Current Zoning: UC (uptown core)
Proposed Zoning: UC(EX) (uptown core, exception)

Approximately 1.90 acres bound by the north side of East Trade Street, west side of North Davidson Street, south side of East 5th Street, and east side of North Caldwell Street.

The petition proposes to allow the development of the Charlotte Hornets practice facilities and associated accessory uses on a lot that is currently used as surface parking.

**SCHEMATIC SITE PLAN**

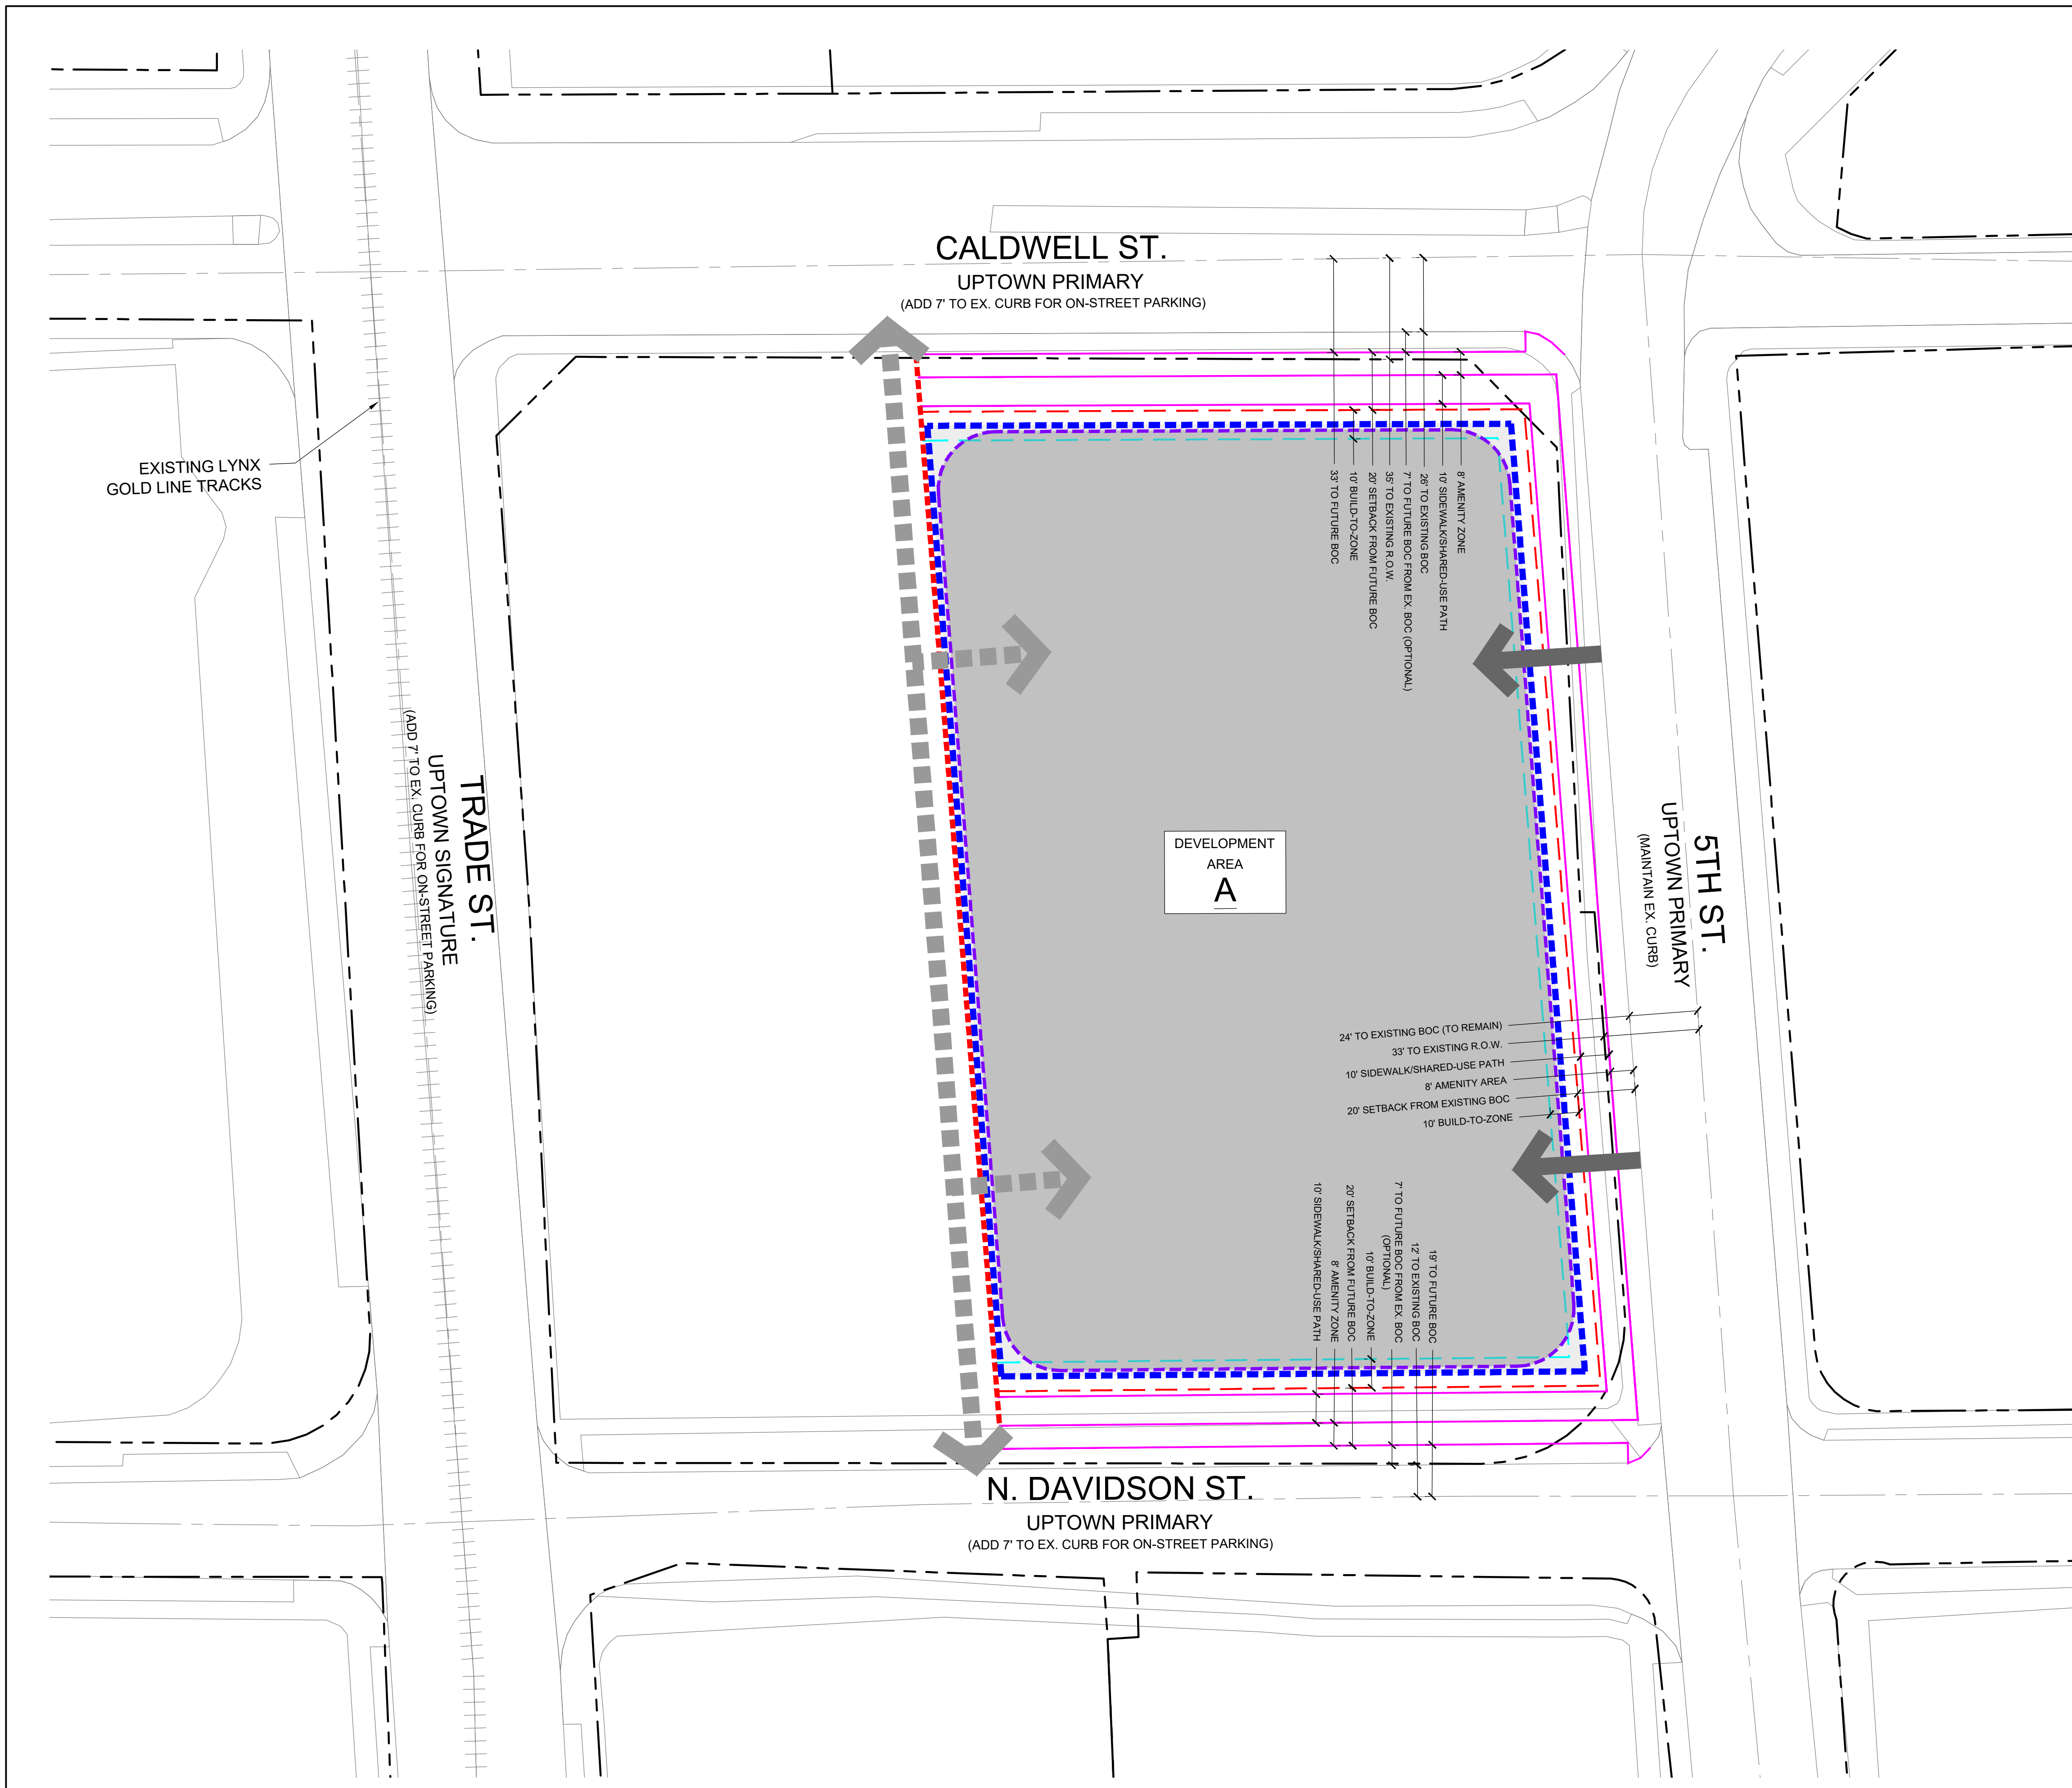
4. ~~Revise the site plan and conditional notes to have the sidewalk alignment be consistent across the site's entire N. Davidson Street frontage.~~ **Addressed**
